From:
To: [Planning](#)
Subject: Planning application 6/2019/2313/FULL
Date: 14 January 2020 17:28:51

SIDE ELEVATION

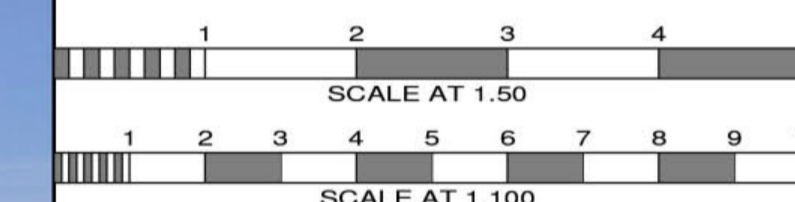
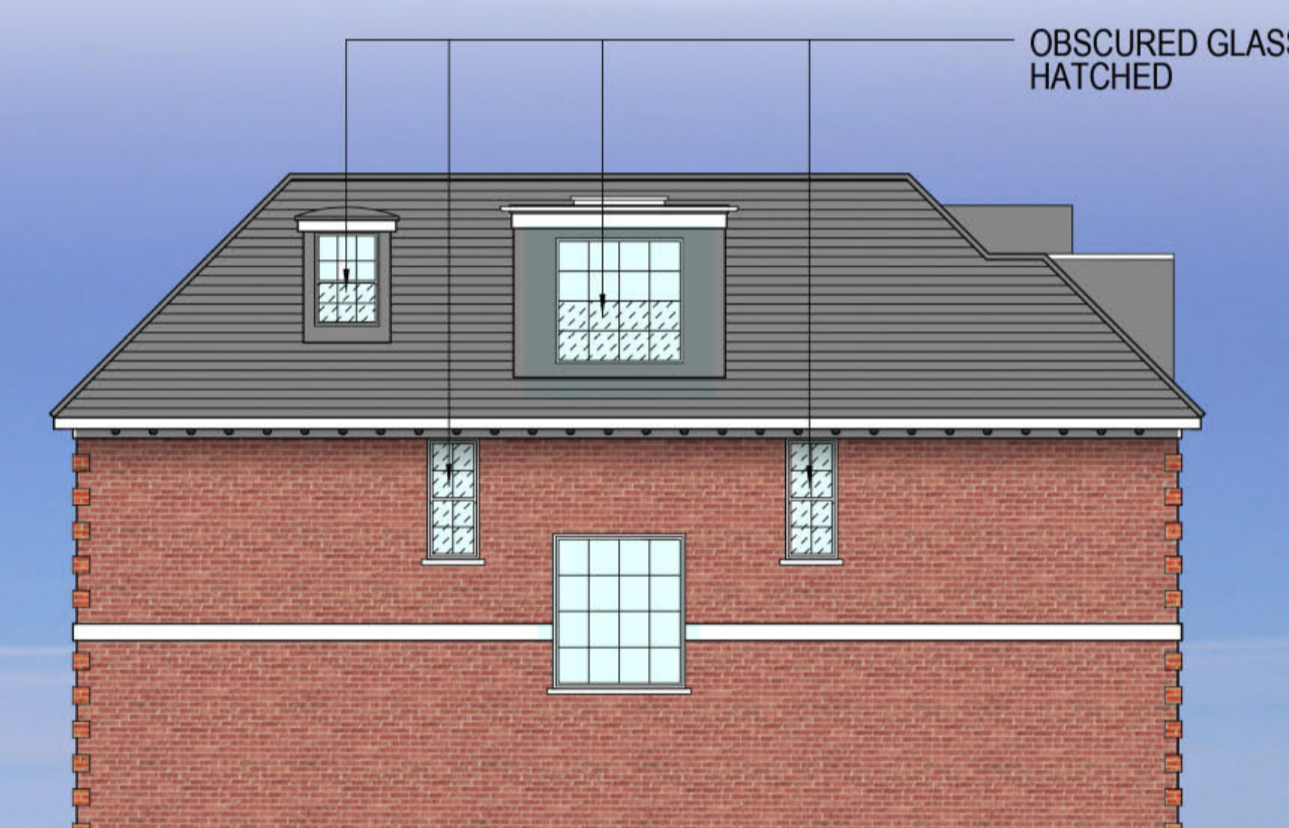
The eastern elevation of house 1 which overlooks our property shows only some of the windows obscured. The very large square of glass ,elevated in the stairwell is shown as unobscured. Although the planning condition states that the glass should be obscured, the diagram of house1 shows it as unobscured.
